Authority	Authority's Reference	Agency Concurrence and Referral	Authority Contact	Authority Notification	Submission Due	Submission Made
NSW Dept. Planning & Environment	SSD-35715221		Prity Cleary	8/11/2022	5/12/2022	9/11/2022

Address	Land Title
10 Morris Grove and 132-152 Wrights Road, Kellyville	Lot 10 DP 1169003

Environmental Impact Statement (EIS) for the Concept and Stage 1 application for redevelopment of William Clarke College. Comprising Concept - alterations and additions to building, increase in student enrolment and ancillary landscaping and car park works, stage 1 - Bryson building, student enrolment and ancillary works.

ENDEAVOUR ENERGY Assets around 10 Morris Grove, Kellyville (Source: DBYD)

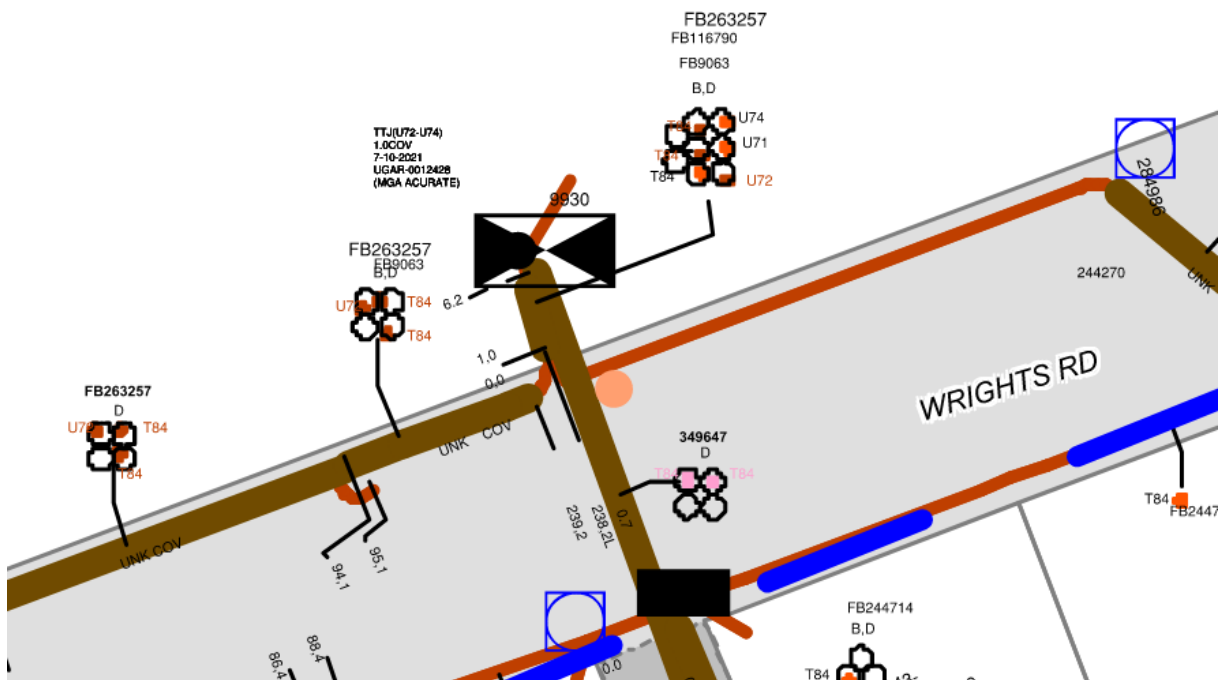
- The Infrastructure Assessment Report does not appear to address in detail whether the electricity services are available and adequate for the proposed development.

3.1 Electricity

The existing site is served by Endeavour (Integral) Energy network using existing substation No 9930 located on Wrights Road. The main switchboard is located within the existing Main Switch Room in Building 14 (6).

There are three further substations on-site – substation No. 54139 located on Cormac Circuit serving the Branwhite Centre, substation No. 25260 located on Morris Grove and substation No. 32433 located on Morris Grove serving the Sports Complex.

The existing substations serving the site are suitably sized to cater for the existing and proposed buildings on site.

- To ensure an adequate connection, the applicant will need to engage an Accredited Service Provider (ASP) of an appropriate level and class of accreditation to assess the electricity load and the proposed method of supply for the development.
- An extension and / or augmentation of the existing local network may be required. The existing padmount substations on and near the site are likely to have some spare capacity, but it is not unlimited and may not be sufficient to facilitate the increase in load from the proposed development.

Other factors such as the size and rating / load on the conductors and voltage drop (which can affect the quality of supply particularly with long conductor runs) etc. need to be assessed. However the extent of any works required will not be determined until the final load assessment is completed.
